Subject: FW: A/50/20/PL - Variation of Condition 2 in respect of A/51/18/PL, Pound Place, Roundstone Lane, Angmering, BN16 4AL

Environmental Health.

Noise Report.

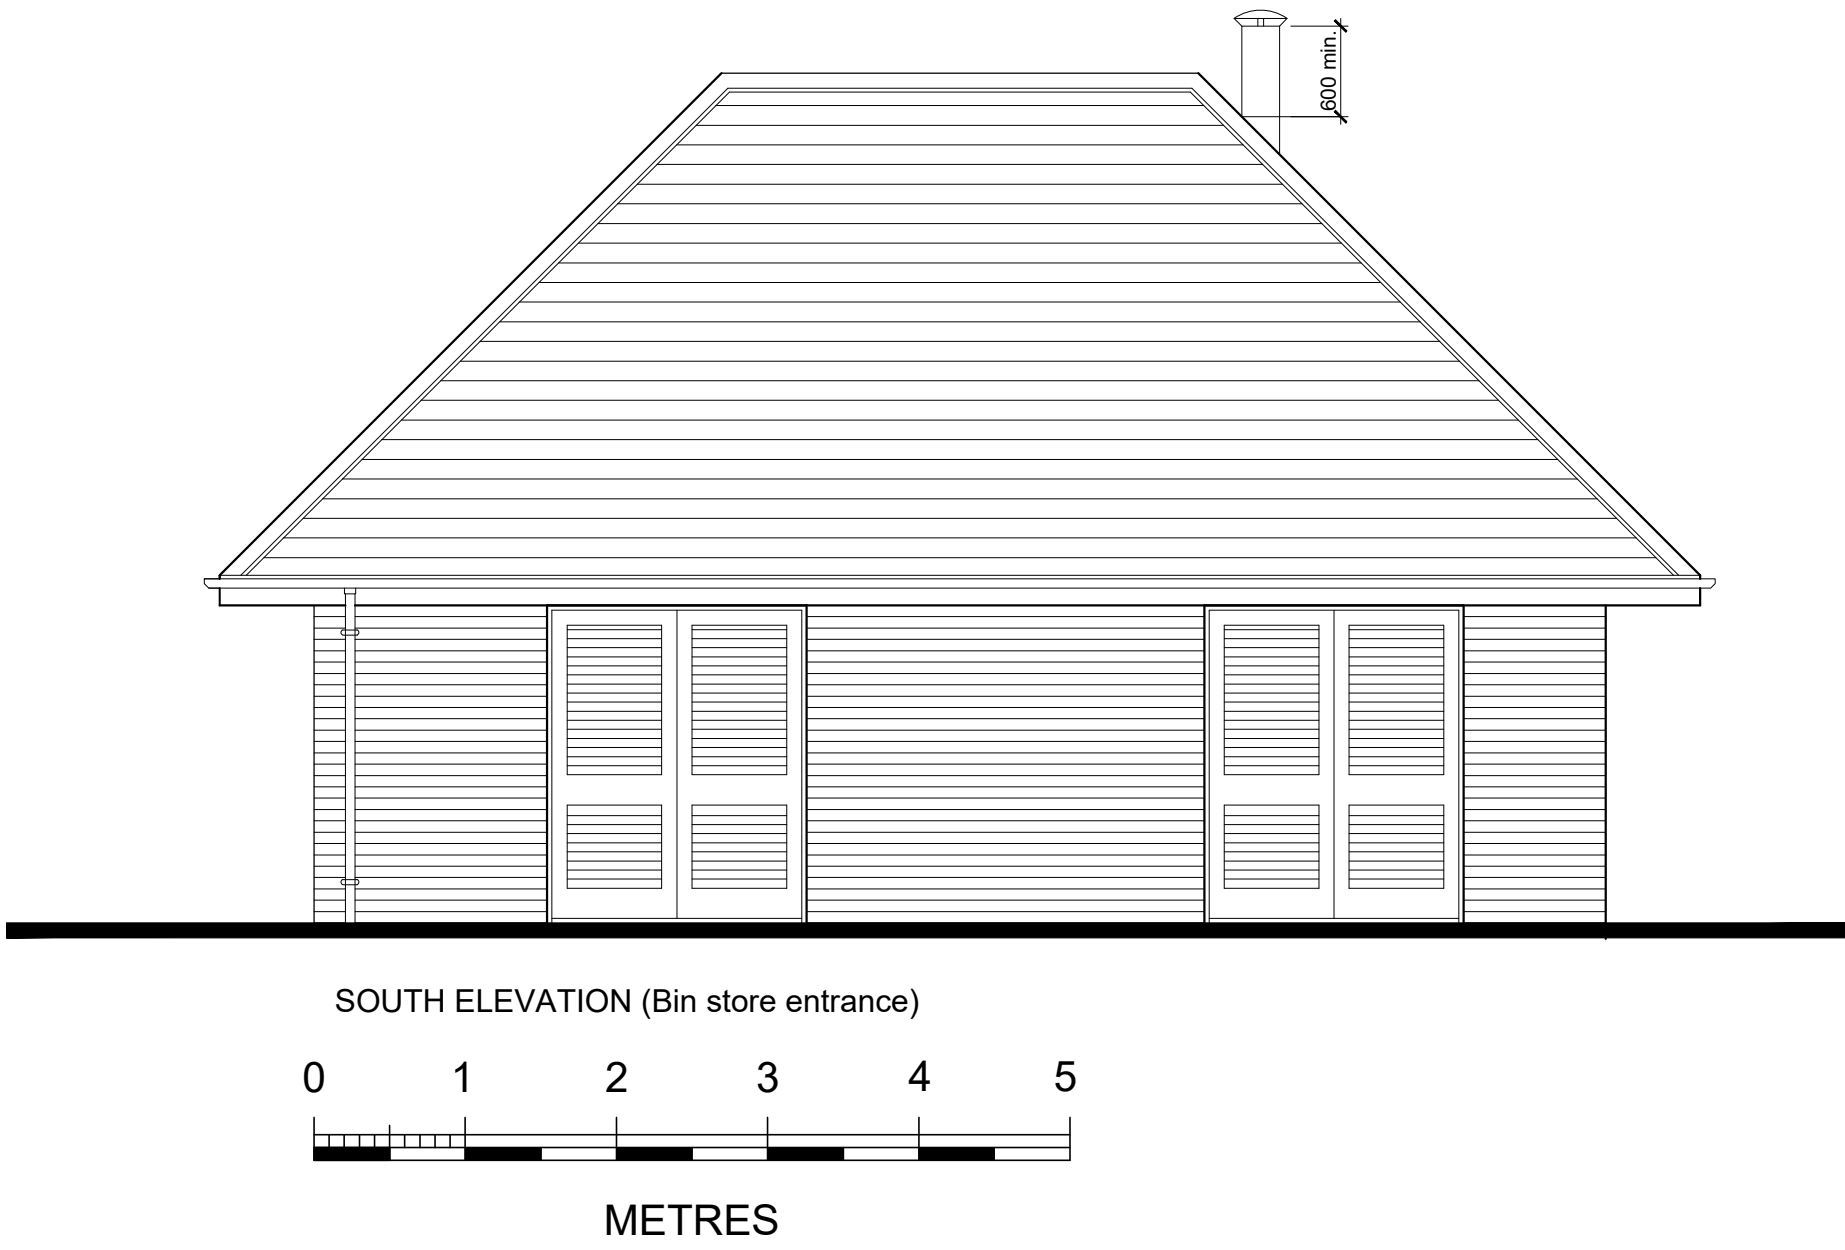
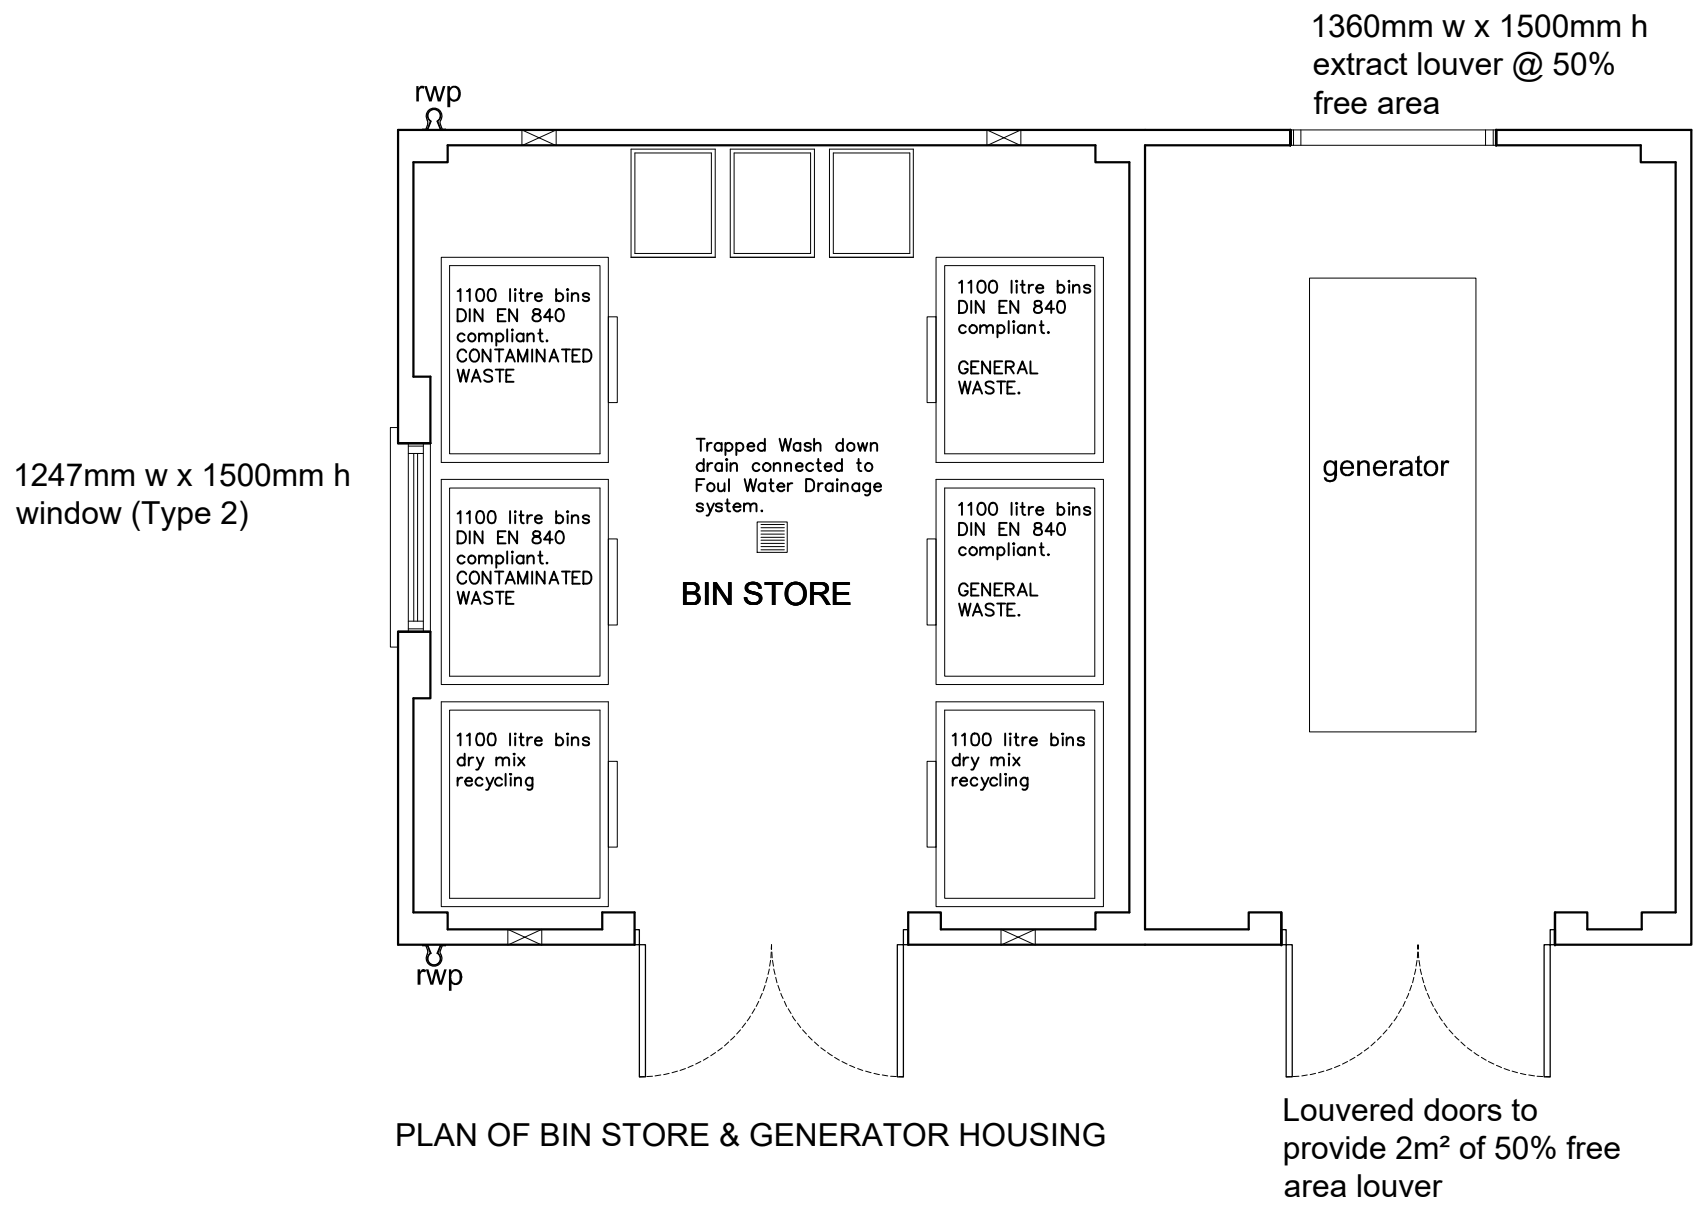
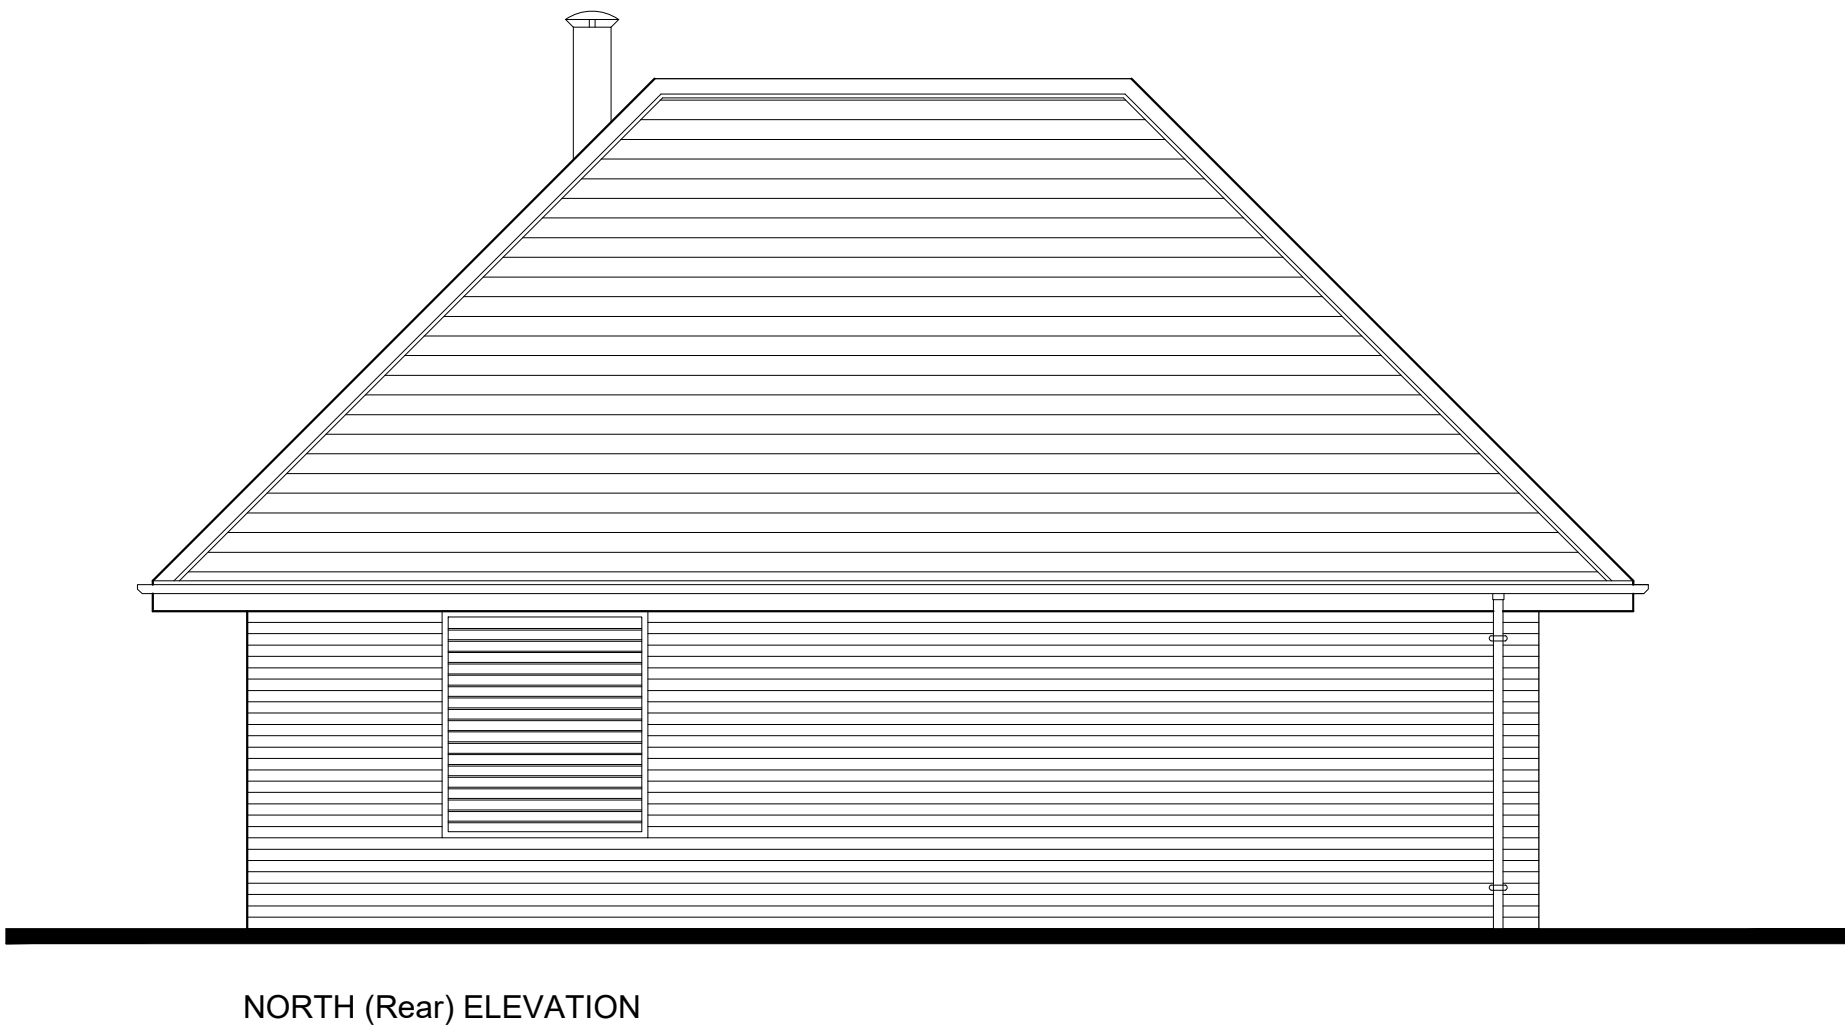
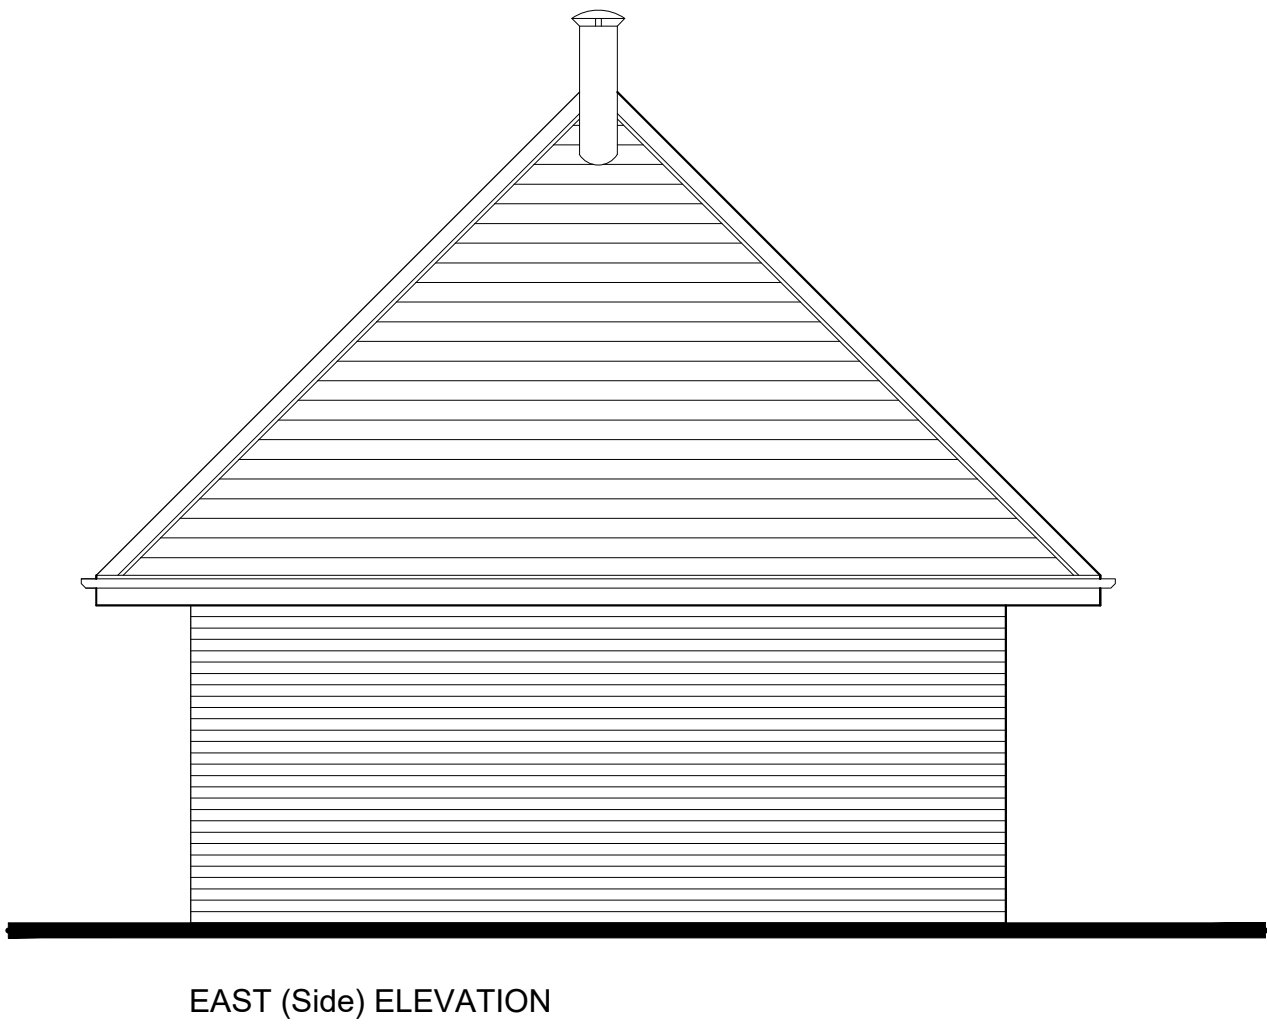
2. An acoustic report will be required in respect of the back-up generator intended for this site in order to demonstrate no adverse impact on surrounding residential units caused by operation of this equipment. Such a report will detail mitigation measures which may be required in this case and shall be submitted to and approved in writing by the Local Planning Authority.

The backup generator shall be maintained in a condition so that it complies with the levels and mitigation measures specified in the approved acoustic report, whenever it is operating. After installation of the approved plant, no new plant shall be used without the written consent of the Local Planning Authority.
